Pearl Place Buildings 1 & 2

ADDENDUM I

September 15, 2006

7

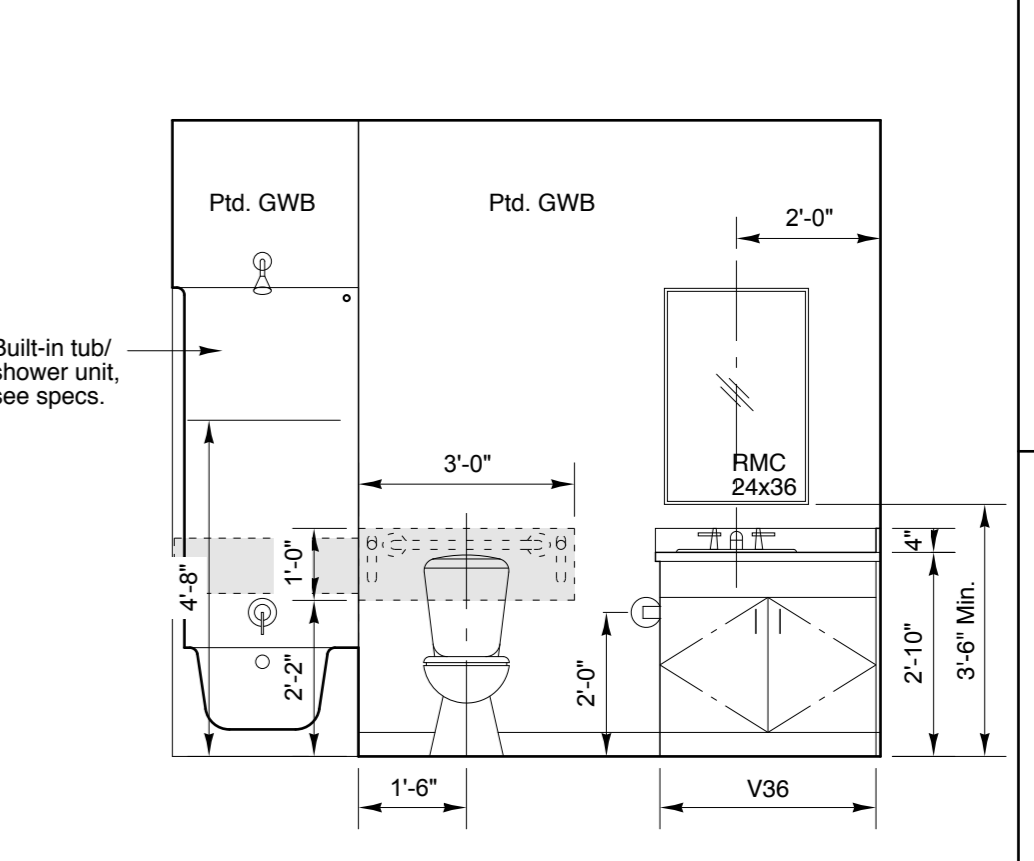
- A7.2** 1. Detail 3 and 7 delete RMC, add SMC.
